Subject: Overlook at Homestead Preliminary Plan (SP238)

The Parks & Community Services Department has reviewed the Overlook at Homestead Preliminary Plan application and has the following preliminary comments of behalf of El Paso County Parks. This application will be presented to the Park Advisory Board on November 8, 2023 and its recommendation will be provided after the meeting.

PERLIMINARY GRADING PLAN NORTH

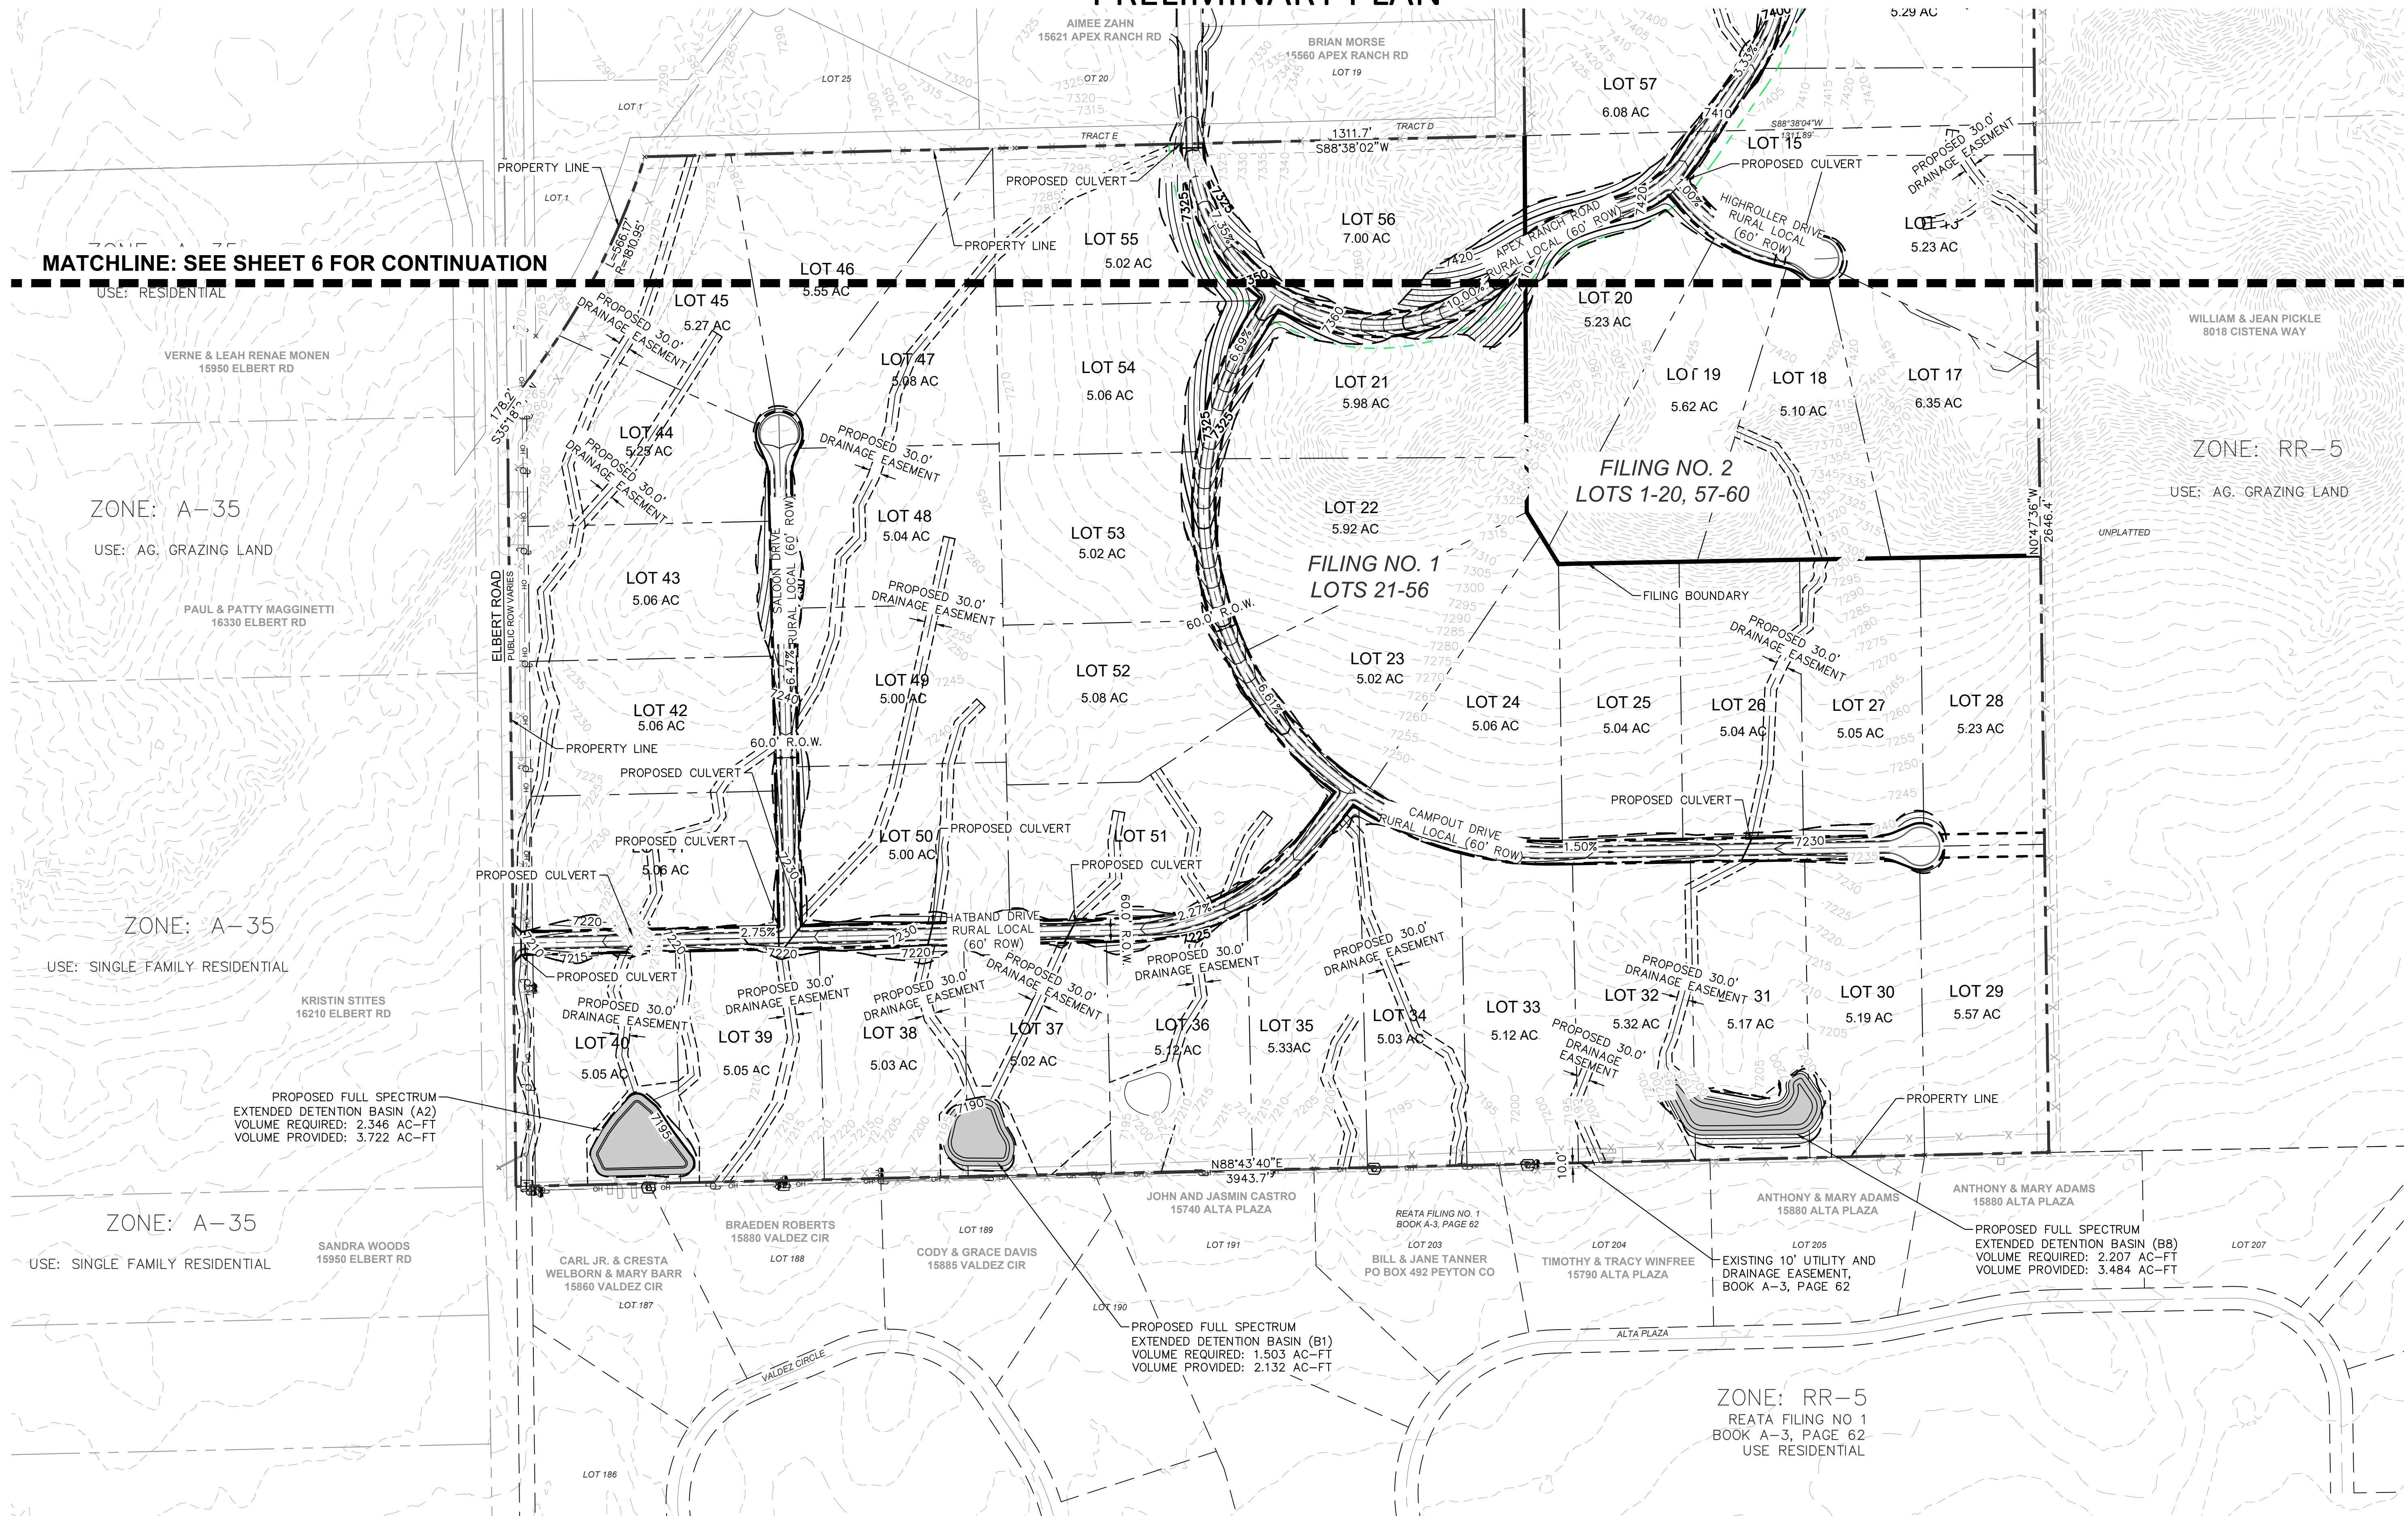
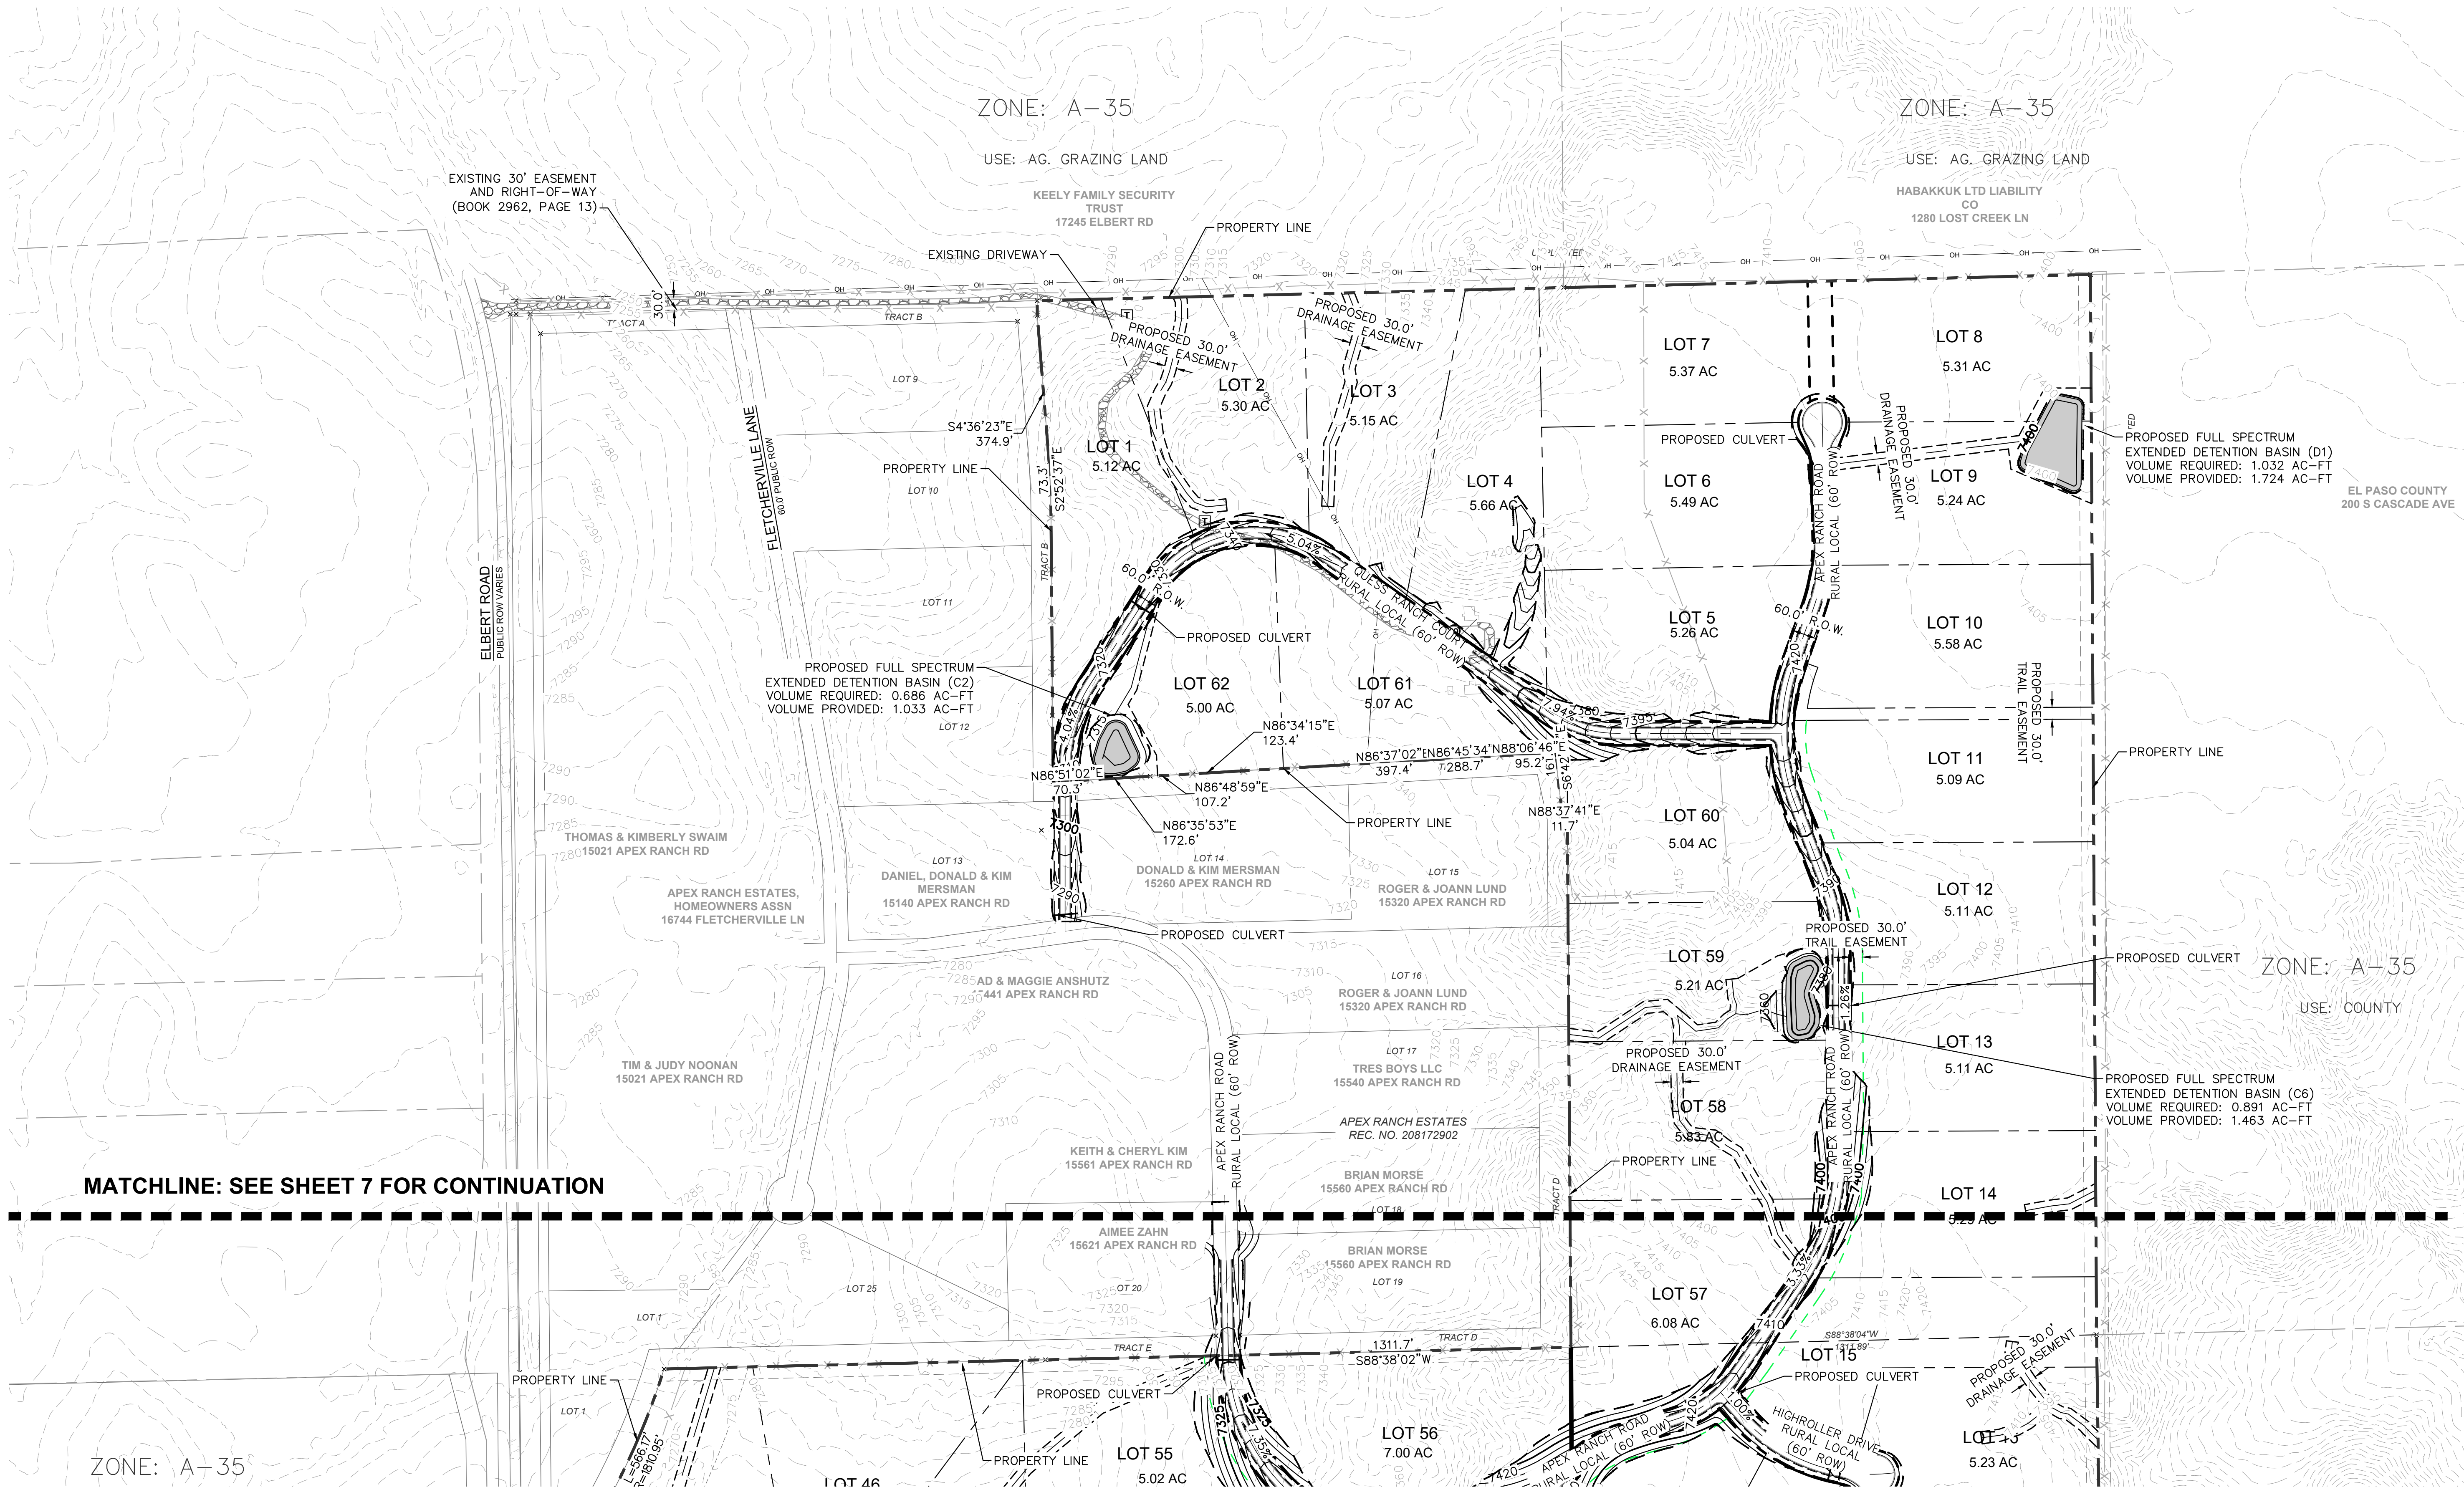
Additionally, County Parks requests that the Palmer Divide Regional trail be graded when the subdivision is constructed so that the trail can be built in the future. As the applicant's grading plan currently shows, although preliminary, grades for a trail along the proposed alignment would not be possible once tied into existing grades on private property outside the trail corridor. It would be best to grade the trail into the hillside when the roads and lots are developed to avoid grading beyond the trail easement in the future.
